From: Christina Stacey
To: Fraser, Jean; Wiar, Shukria
Date: 12/17/2015 10:48 AM
Subject: Fwd: RE: Permit #2697 - Irving Oil, 2282 Congress St, Portland, ME

I am in the process of reviewing your submitted sign permit application for the Irving Station at the above-referenced address. I had a few questions/requests as follows:

Drawing file: Submissions / Building Elevations.pdf

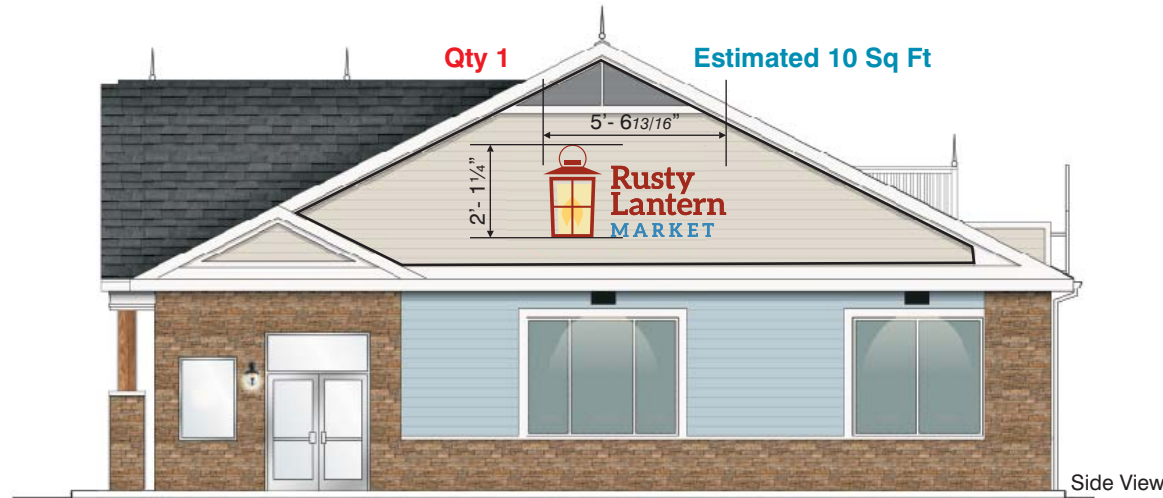
Canopy signs - allowed 2 signs (must be on opposing planes of the canopy), each sign 20 sf max, with a max vertical dimension of 2'. They are proposing two signs on two adjacent planes (the north and east sides), each sign 31.7 sf in size with a vertical dimension of 4'3"

Building signs - allowed one sign for each activity - 30 sf for principal use and 10 sf each "additional major activity", must not exceed a 2' vertical dimension. They are proposing two signs, both for the auxiliary use ("Rusty Lantern Market"). The front sign would be 30.25 sf with a 3'8" vertical dimension and the side sign would be 11.63 sf with a 2'1" vertical dimension.

Thank you for sending. I will be working with Jean Fraser in the Planning Division on reviewing this waiver appeal. I had a question - do you have the vertical dimension of the Irving canopy signs including chevrons? I ask because the normal maximum vertical dimension for canopy signs is 2', so if these are taller then that is another variance waiver.

- 1) A sign waiver appeal requires a fee of \$75. Attached please find an invoice for that fee. It can be remitted either by mail or electronically by contacting buildinginspections@portlandmaine.gov or 207-874-8703.
- 2) What is the proposed height of the canopy logos, including the top & bottom chevrons?
- 3) Is it correct that the store building will only have the single "Rusty Lantern" sign with a total size of 9 sf?

Hi Christina,
The total height of the canopy icons including the chevrons is 4' 2.75".
Please let me know if you have any other questions.

2) What is the proposed height of the canopy logos, including the top & bottom chevrons? – The proposed height of the canopy icons with the top and bottom chevrons is 31.72 sq. ft. We will only have (2) now instead of (3).

3) Is it correct that the store building will only have the single "Rusty Lantern" sign with a total size of 9 sf? – The building will have a front sign of 30 sq. ft. and a right side sign of 10 sq. ft.
